**From:** [Virginia Waller](#)  
**To:** [Bruce Bassett](#); [Debbie Bertlin](#); [Dan Grausz](#); [Jeff Sanderson](#); [Wendy Weiker](#); [David Wisenteiner](#); [Benson Wong](#)  
**Cc:** [Scott Greenberg](#); [Robin Proebsting](#)  
**Subject:** MICA requires Disclosure and Vote  
**Date:** Tuesday, January 31, 2017 6:44:11 PM

We live in Mercedale, near the Thrift Shop, and use Mercedale Park daily. We generally supported the MICA development, based on the announced ground lease proposed in the northwest corner of the park. But we are concerned with the newly revised plans that indicate the project intends to swallow a far greater portion of the park than what has been disclosed.

SHEET NAME
SITE AND PAVING PLAN

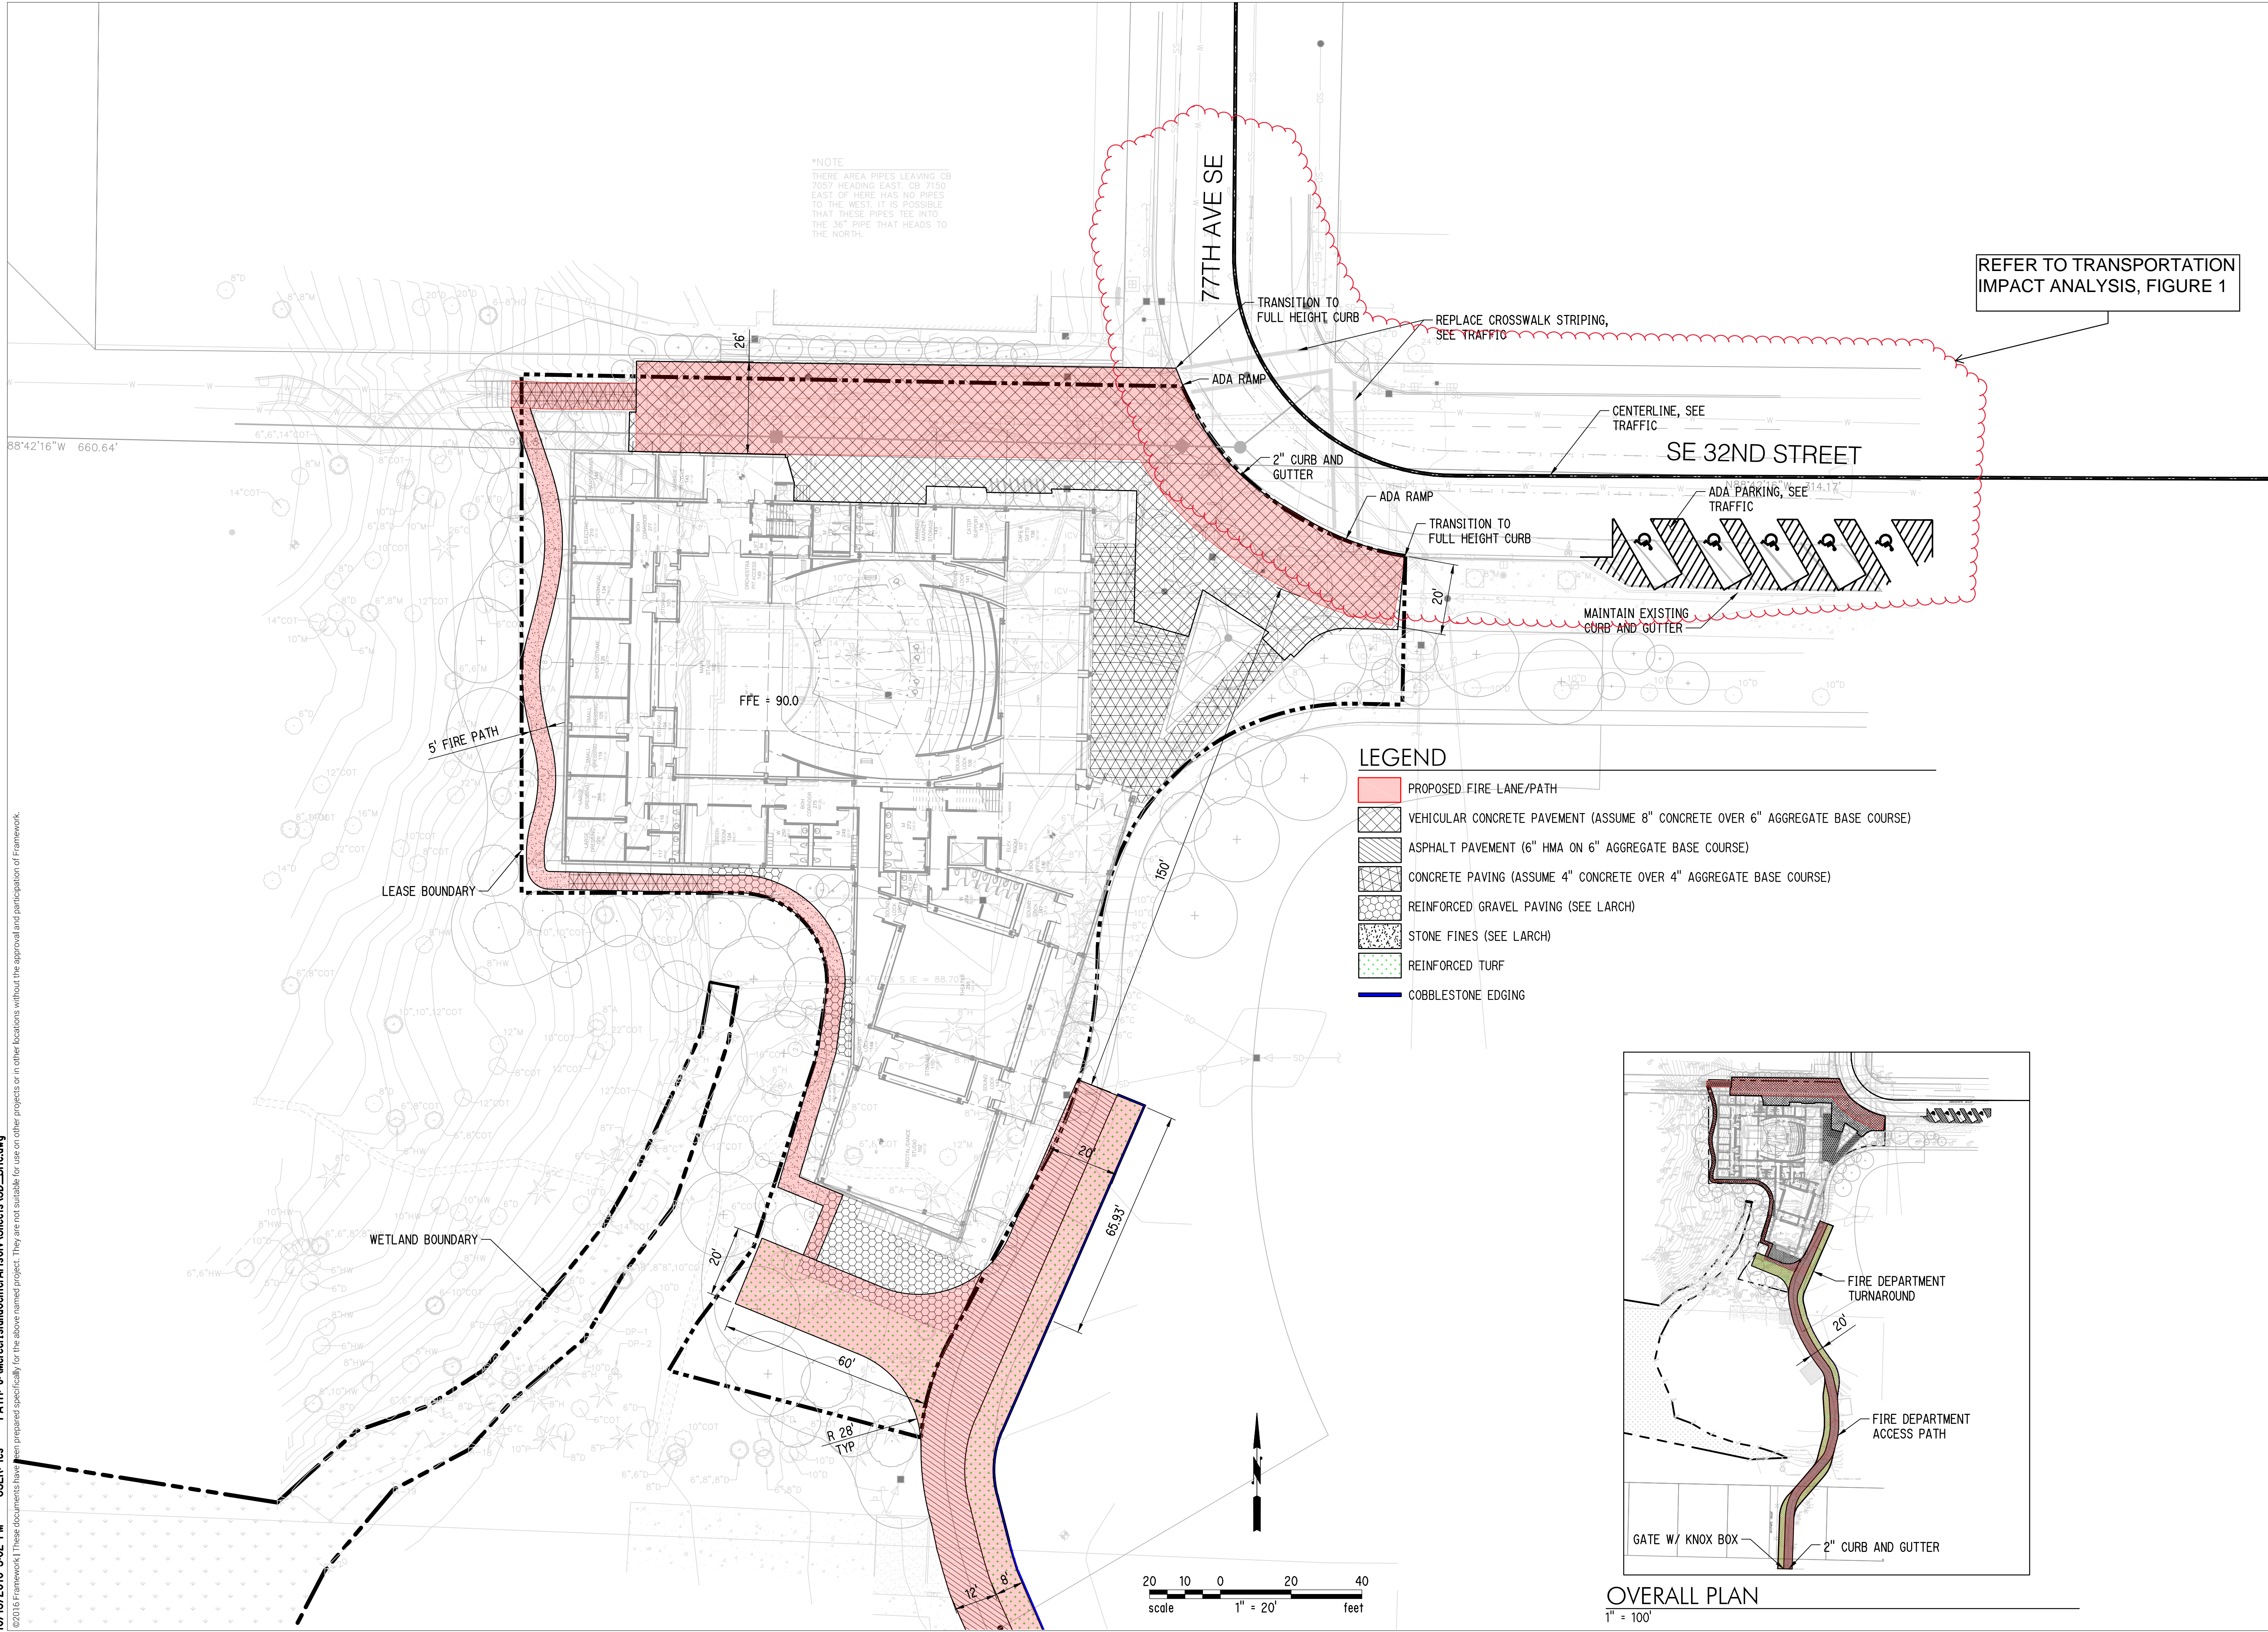
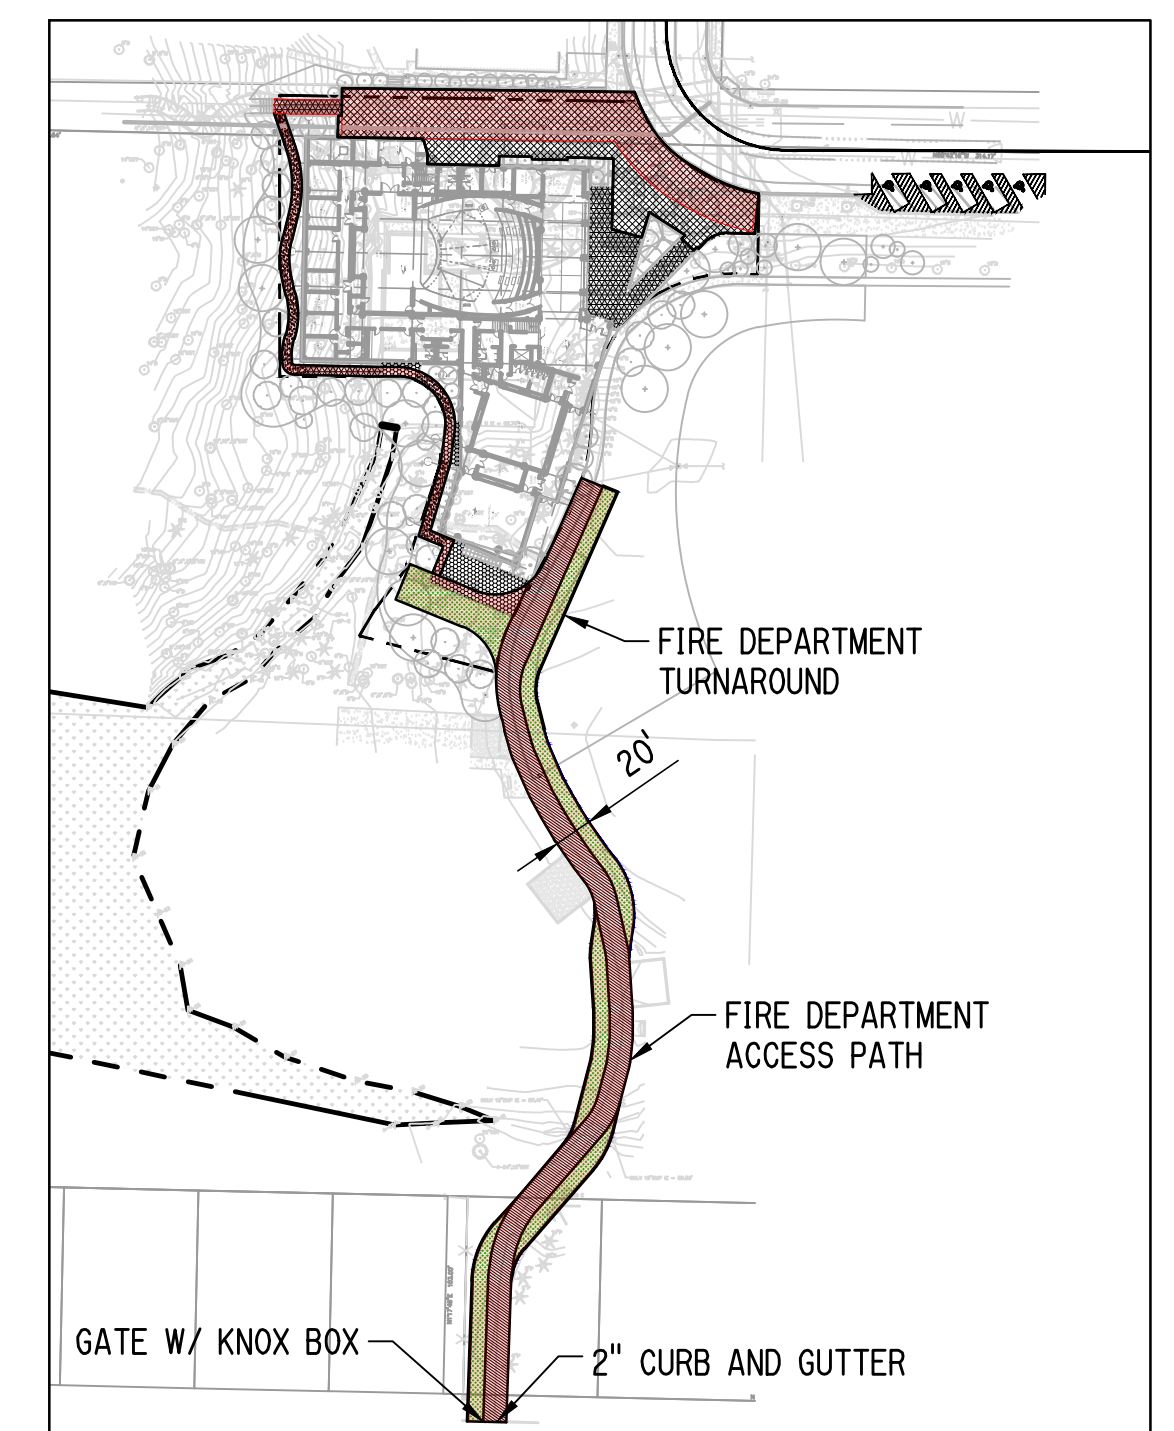
1. an additional @4,000 ft<sup>2</sup> area for the 2-lane wide fire lane running the length of the park;
2. a large area in the middle of the grassy playfield for a protruding cement water retention pond;
3. 4 well-used public, street parking spaces on the north side of the park to serve as restricted handicapped spaces serving MICA alone. Given that those spaces enjoy substantial turnover, this will likely force these parkers into the residential Mercedale neighborhood.
4. a large area of the park to serve as ponds, which will need treatment for mosquitoes (and diminish park use if they are insect breeding grounds or smelly).

Most disturbing, however, is MICA's conspicuous failure to show mandatory the fire truck turnaround. Based on conversations with the fire department, and a quick look at the Fire Code, I understand that a fire lane that is over 150' in length requires either a 96' diameter circle at the top, or a 120' wide 'Y' to allow fire trucks to turnaround. Why is this absent from the newest drawings?

At a minimum, if this new design is approved, the lease needs to contain stiff penalties to prevent MICA from using the fire lane for deliveries, parking and garbage collection as the years pass, addressing maintenance of the road, requiring insurance and addressing the smell and mosquito issues. Traffic remains a substantial concern, and re-designating City parking as handicapped parking is not an acceptable solution – handicapped parking needs to be on the MICA site, not on the street.
